DECISION DELEGATED TO DEVELOPMENT MANAGER

Application No: H15-1013-19 **Applicant:** Mr A Hubbard - Red Roof Developments

Proposal: Details of archaeology, materials, landscaping and agreement to tree work (Conditions 3, 6, 7 and 8 of H15-1103-18)

Location: 6 Town Drove Quadring Spalding

Garage East
1 : 50

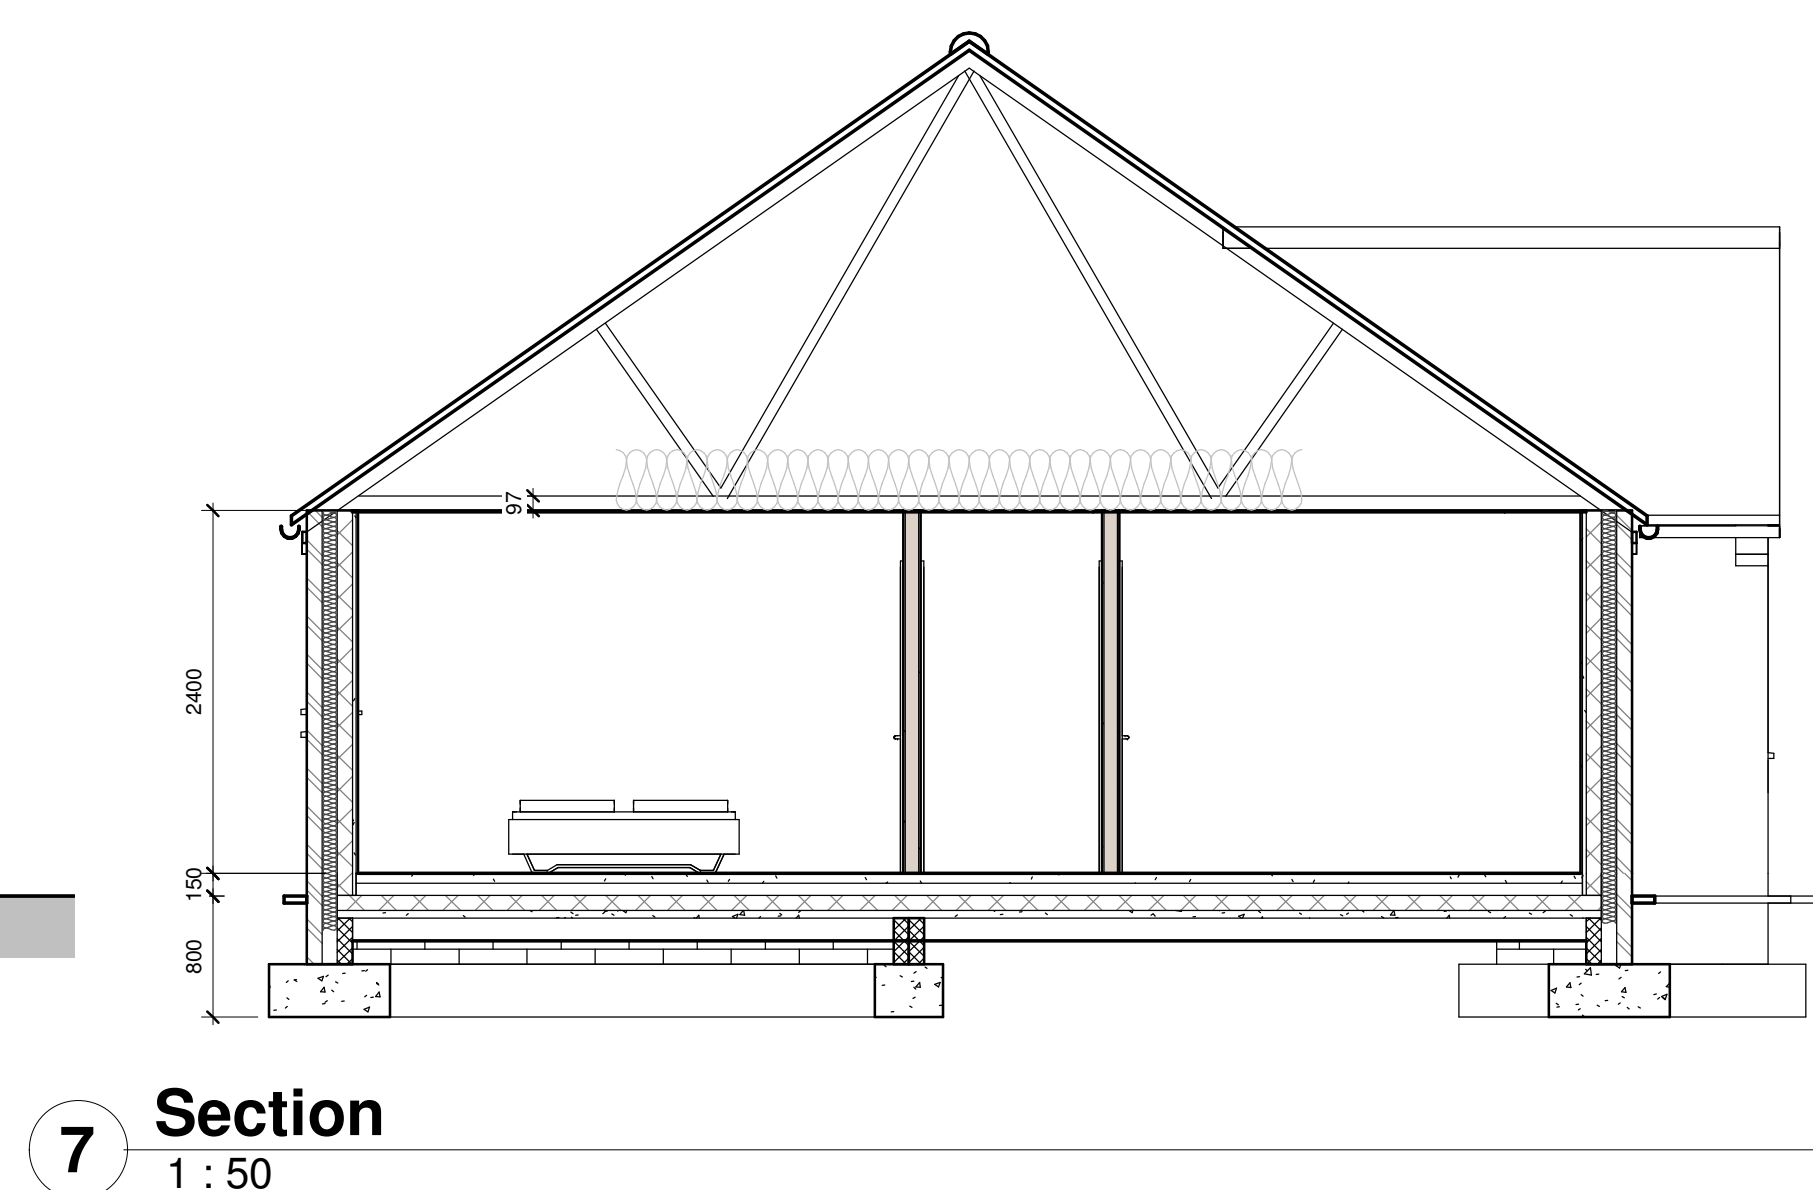
The proposed materials of construction are Forterra Hampton Rural Blend bricks and Sandtoft Double Pantile Rustic tiles. This is acceptable taking into account the variety of materials used in the construction of existing buildings in the vicinity and the specific materials of the Grade II Listed Building (Town Drove (south side) further west (red facing brick and terracotta pantiles).
